# KITTITAS COUNTY DEPARTMENT OF PUBLIC WORKS

## MEMORANDUM

SUBJECT: The Grove Student Housing Traffic Impact Analysis

Revised site Plan July 7, 2006

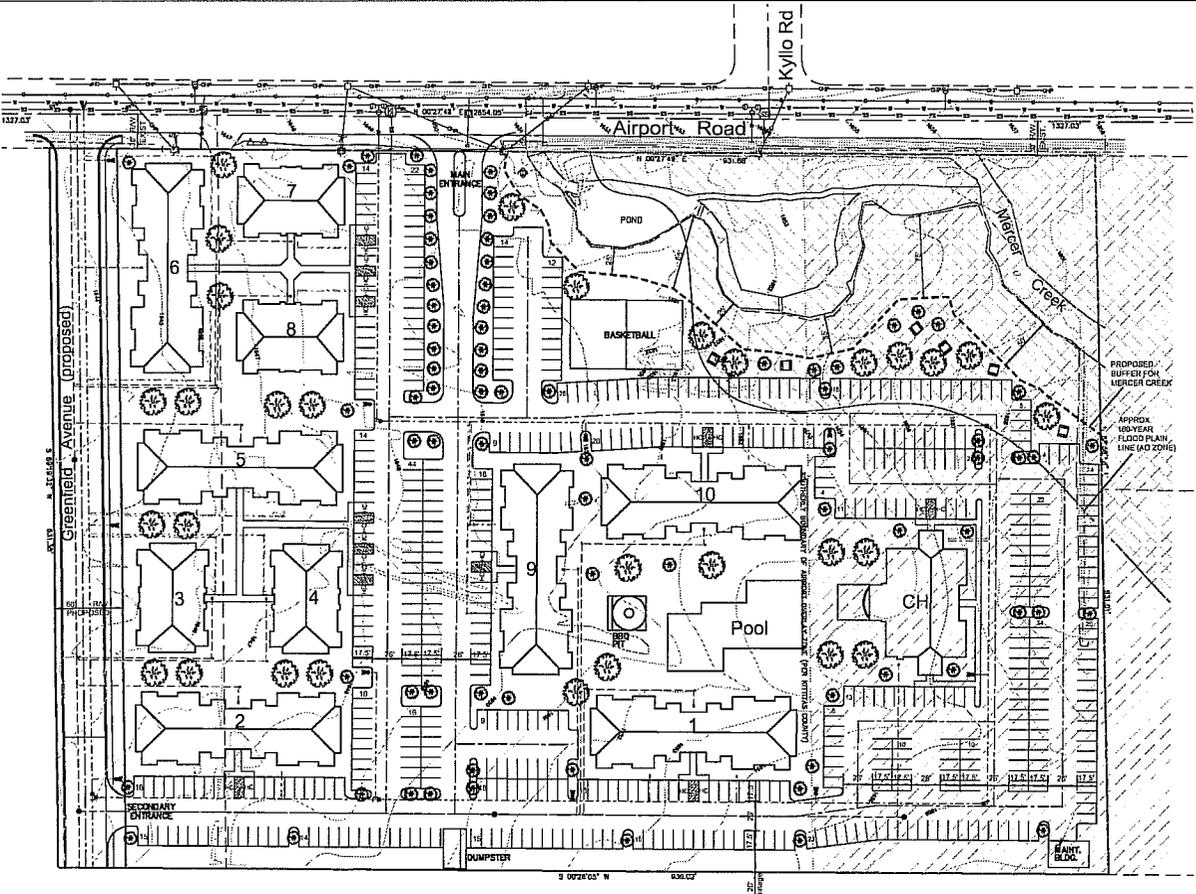
Our office has reviewed the Traffic Impact Analysis, as well as, some of the related correspondence. I share the City of Ellensburg's concern that only 30% of the ADT's are considered to be from motorized modes of transportation. This does seem a little low; however, it's hard to say whether an increased percentage would make a significant difference in the mitigation for the overall traffic impacts. That being said, if 70% of the ADT's are from non-motorized modes of transportation then I would suggest that the flow of pedestrian traffic be a priority in the layout of the parking areas and that provisions be made to accommodate the anticipated volume of pedestrian and bicycle traffic throughout the site.

The assumption that 70% of the trips will be non-motorized trips greatly reduces the traffic impacts and there isn't any backup information indicating how they made this assumption. Maybe the City would have a good idea from some of our other University related apartments. If this assumption is valid and you require them to change their on-site parking plan like you mentioned to me, then we should consider having them cluster the parking away from Airport Road and have paths that directly connect to Airport Road & sidewalks to make the non-motorized usage more predominant and pedestrian friendly. Now they have to walk & bicycle through parking as it surrounds the complex on all sides. We should also require that they have bicycle storage to house the large number of bikes anticipated.
